Town & Country Planning Act 1990 (as amended)
Town & Country Planning (Development Management Procedure) (England) Order 2015
Application for Planning Permission for Works or Extension to a Dwelling

Development Single storey ground floor rear extension and new roof to provide habitable accommodation.

Location Innisfree 26 Belle Meade Close Woodgate Aldingbourne

Proposed Block Plan

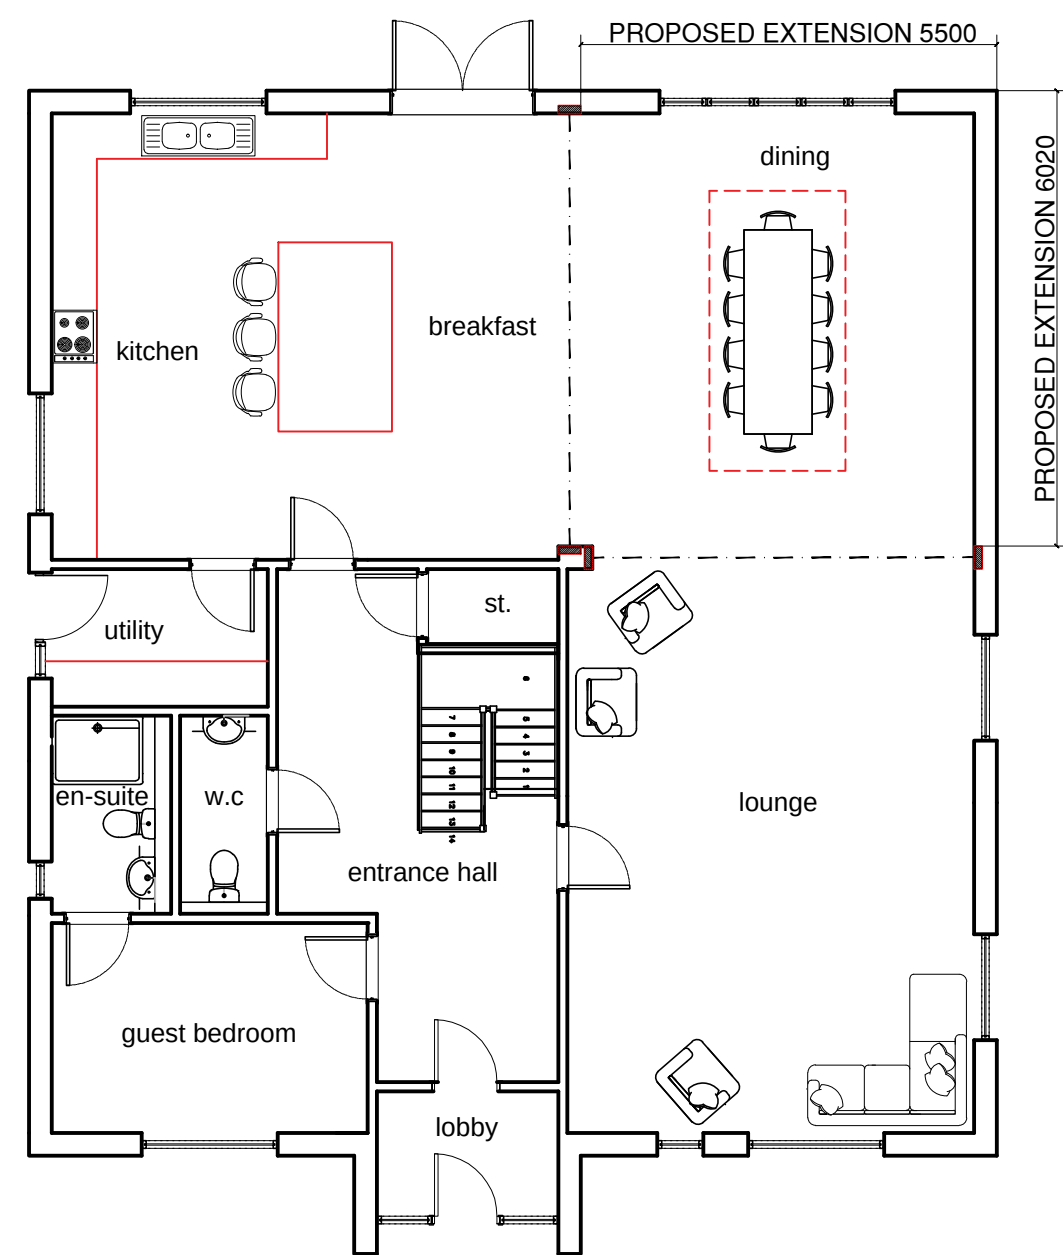
Block Plan

You are required to annotate the dimensions from each side of the proposal to the site boundary.
